Job No. 176147

June 23, 2022

Re: Response to CGS Comments dated 5.17.22
Falcon Meadows at Bent Grass, Filing No. 3
El Paso County, Colorado

FALCON MEADOWS AT BENT GRASS FILING NO. 3

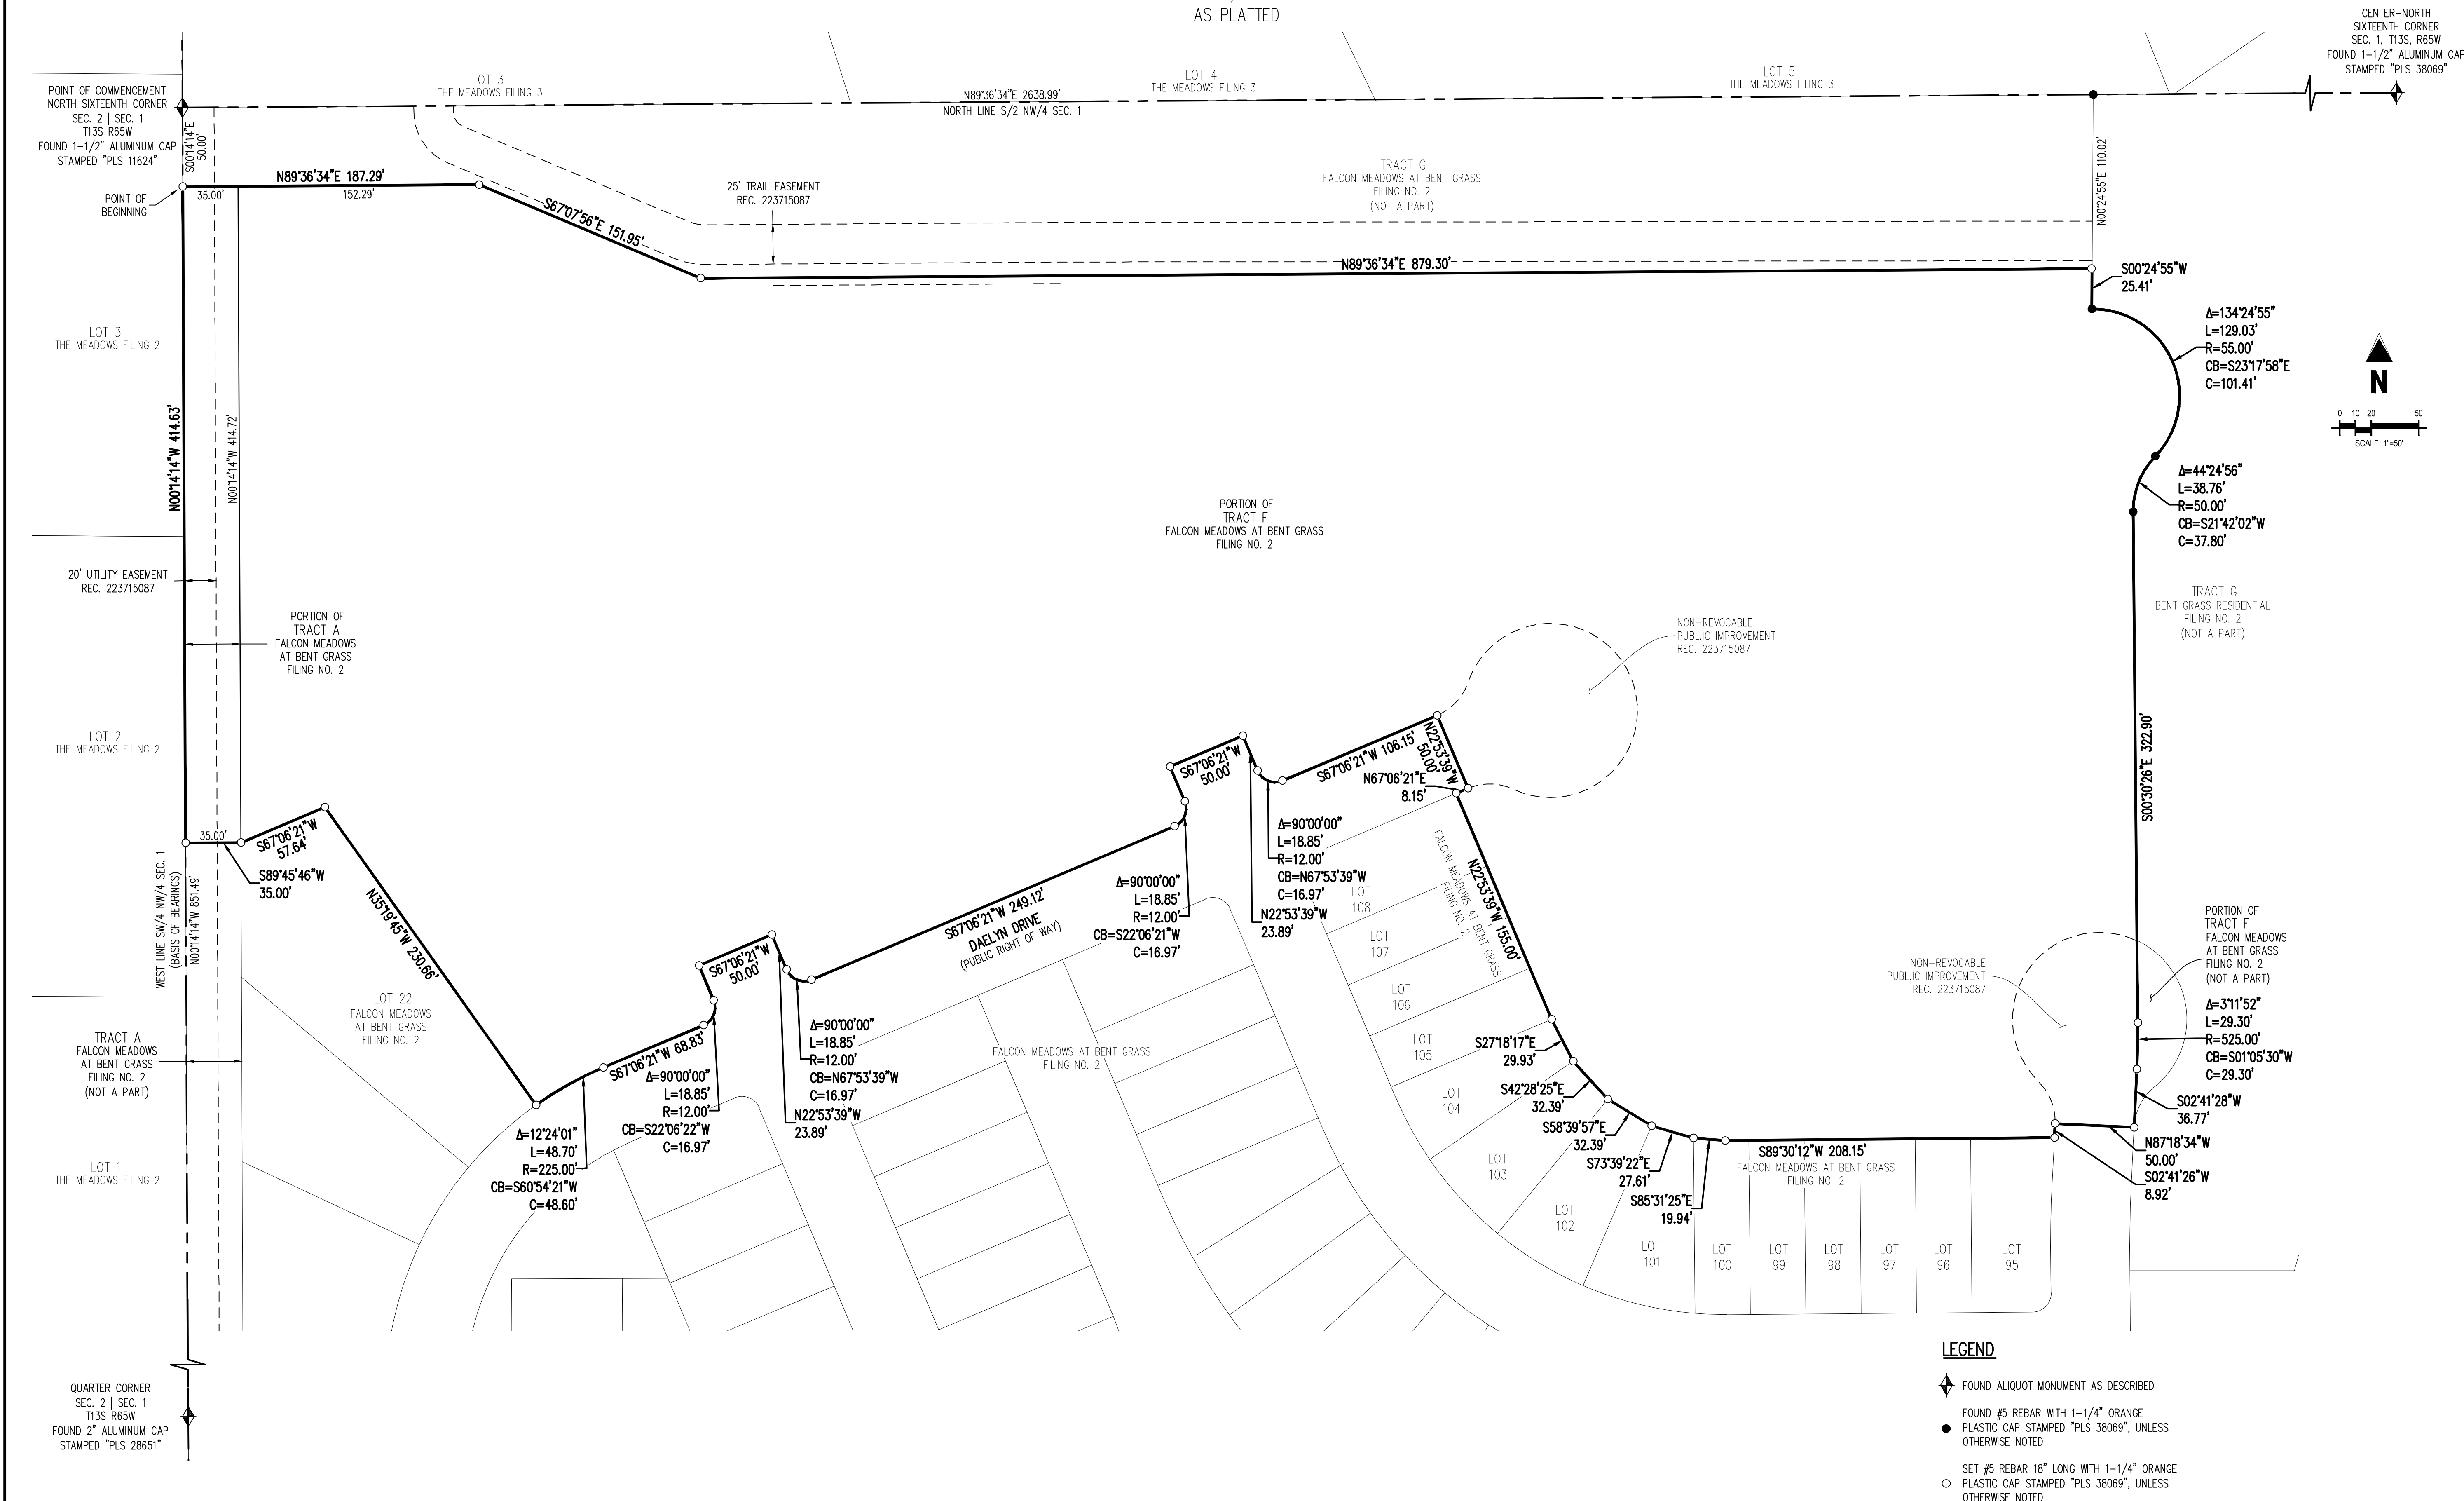
RMG's engineering and geology map (Figure 10) depicts lots 1-4 "to be restricted to non-basement construction," while lots 5-49 include no restrictions. However, groundwater was encountered at a depth of 10 feet below grade in RMG's test borings 6 and 11 (Filing No. 2) drilled near lots 33-38 of Filing No. 3. Therefore, if basement levels are planned for lots 5-49, CGS recommends the county require groundwater monitoring/observation to verify that groundwater is at depths greater than 14 feet of the original ground surface. This monitoring/observation program should be conducted immediately (before final

plat approval) and checked frequently following drilling operations to determine if basements are feasible based on the developer's restrictions. Additionally, the proposed floor levels must be at least three feet above maximum anticipated groundwater levels and maintained year-round. If groundwater is determined to be within 14 feet of the original ground surface, then these lots should also be "restricted to non-basement construction" and noted on the final plat. By not addressing this issue early in development, it becomes the homeowner who eventually learns if basements are feasible or not based on lot-specific soil investigations.

The groundwater depths in TB-6 and TB-11 were inadvertently reported as 10 feet below original ground surface. Review of the boring logs presented in our Job No. 169845 (attached and included as Appendix C in the report referenced above) and other data contemporary to the preparation of 169845, the 10-foot depths noted alongside test borings TB-6 and TB-11 appear to be a reference to the depths of claystone bedrock below the original ground surface in those two borings, rather than the depths to groundwater. Groundwater was not encountered in test borings TB-6 and TB-11, which extended to termination depths of 20 feet. Therefore, no basement restrictions are proposed for lots 5-49.

Additionally, RMG's recommendation that basements be restricted where groundwater is within 14 feet of the ground surface is based on the anticipated seasonal fluctuations. It is our opinion that basement restrictions are required on lots where the groundwater depth is less than 14 feet. This allows for the current groundwater condition (at the time of drilling) and the anticipated fluctuations. Where groundwater is deeper than 14 feet, neither basement restrictions nor a monitoring/observation program should be required.
